# KIRKLEES METROPOLITAN COUNCIL INVESTMENT & REGENERATION SERVICE

| Reference No:         | <b>2023/62/93683/E</b>                                                                                                                         |
| Site Address:         | Hill Crest, The Village, Thurstonland, Huddersfield, HD4 6XX                                                                                   |
| Description:          | Erection of first floor extension with front porch, rear dormers and associated internal and external alterations (within a Conservation Area) |

PROPOSED GROUND FLOOR PLAN 1:100

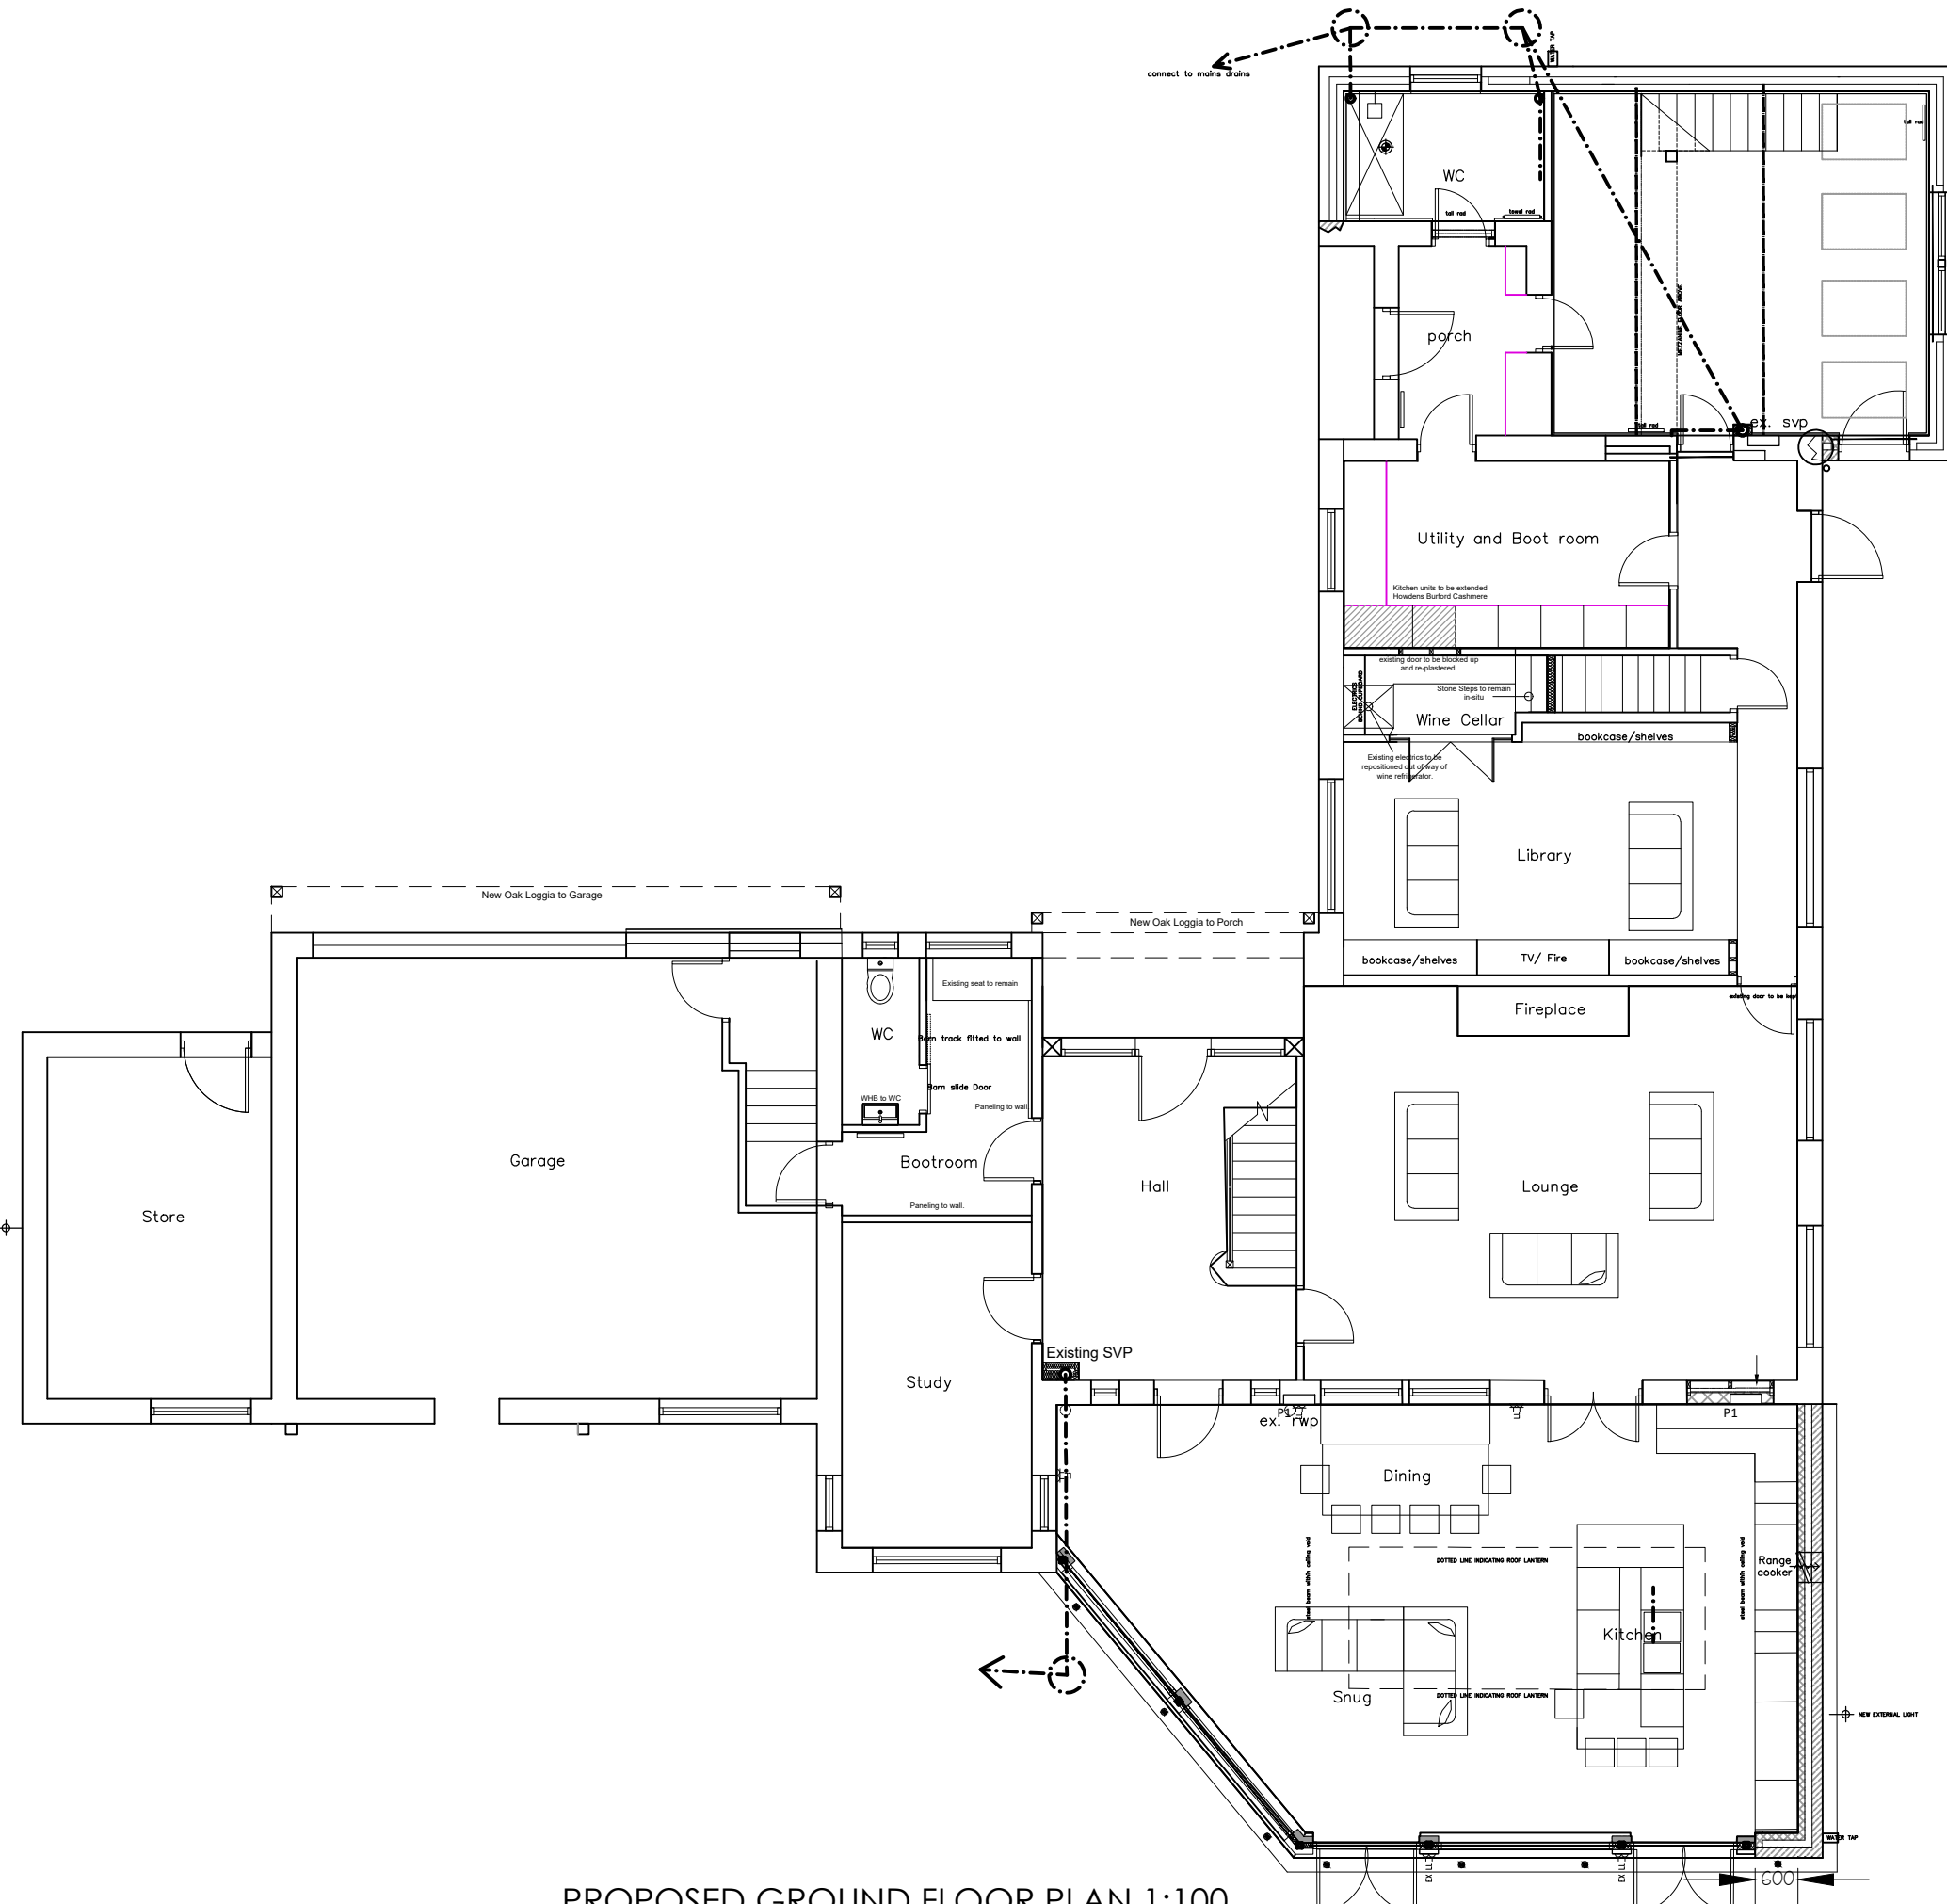
KC Conservation & Design – Conservation & Design were consulted as the site is within a conservation area and sits behind grade II listed buildings. Initially, there were concerns with the design as it included a front elevation dormer. Amended plans were requested to replace the dormer with mullion windows as to not disrupt the frontage and setting of the conservation area and listed building. The amended plans were found to have a neutral impact to the setting of the conservation area and listed building.

Amended plans were requested to remove the dormer and include mullion windows on the front elevation.

The first-floor side extension is not set back from the front elevation, however it follows the building line of the dwelling which is an appropriate design consideration to retain its character. It is set down below the ridgeline of the original dwelling and has the appearance of being subservient. The extension is designed with a pitched roof which is consistent with the host dwelling and wider building group. Due to the layout of the building and site, there will be sufficient space retained to the side. The rear of the property currently has a high amount of glazing and is more modern in style. The addition of the dormers will therefore contribute to its appearance. As the dormers are set into the walls, they will blend into the dwelling and will not be visible from the front of the property.
